Application for a Non-Material Amendment Following a Grant of Planning Permission

Reserved matters application for access, appearance, landscaping, layout and scale on approved application 19/03666/OUT

22/00079/REM

**Sheet Title**  
Proposed Elevations- Unit 1

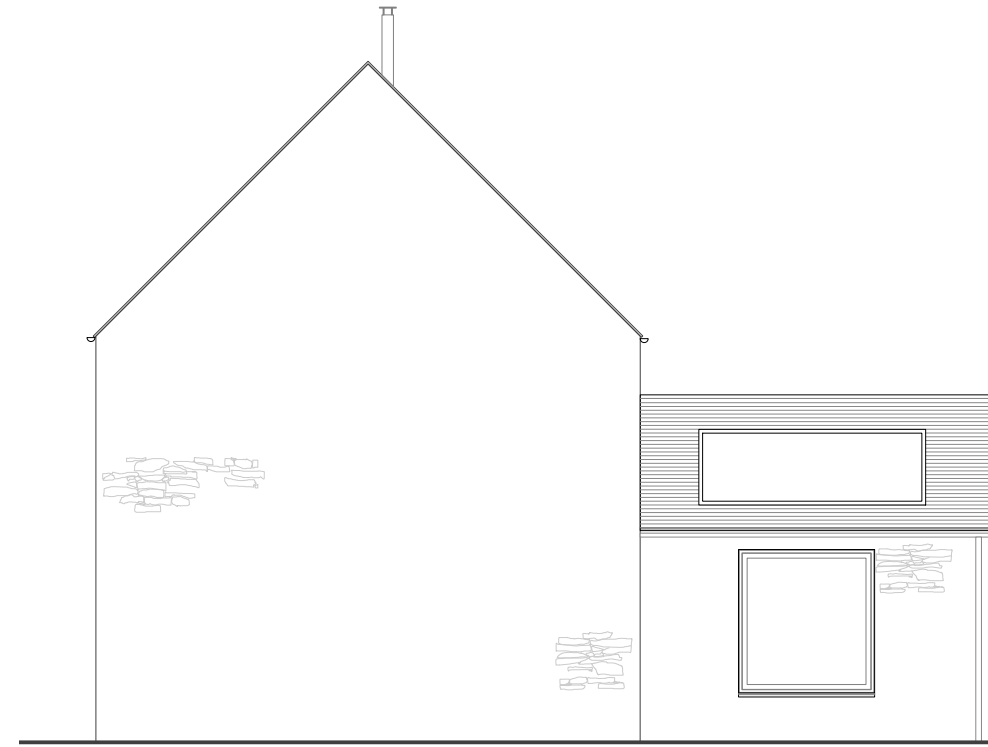
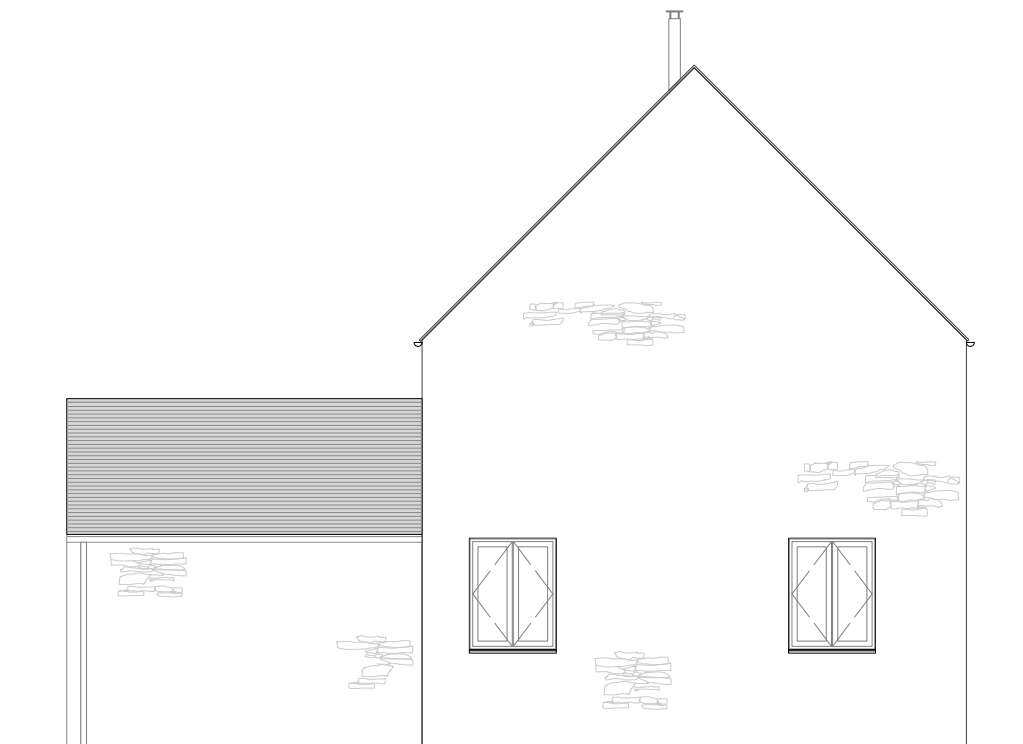
1. Remove of water table detail to all stone gables of all units.
2. Change front sliding doors of Unit 1 into smaller fixed window.

1. Client requested in order to simplify the buildability of construction with the proposed timber frame.
2. To reflect internal layout amendments to the plans.
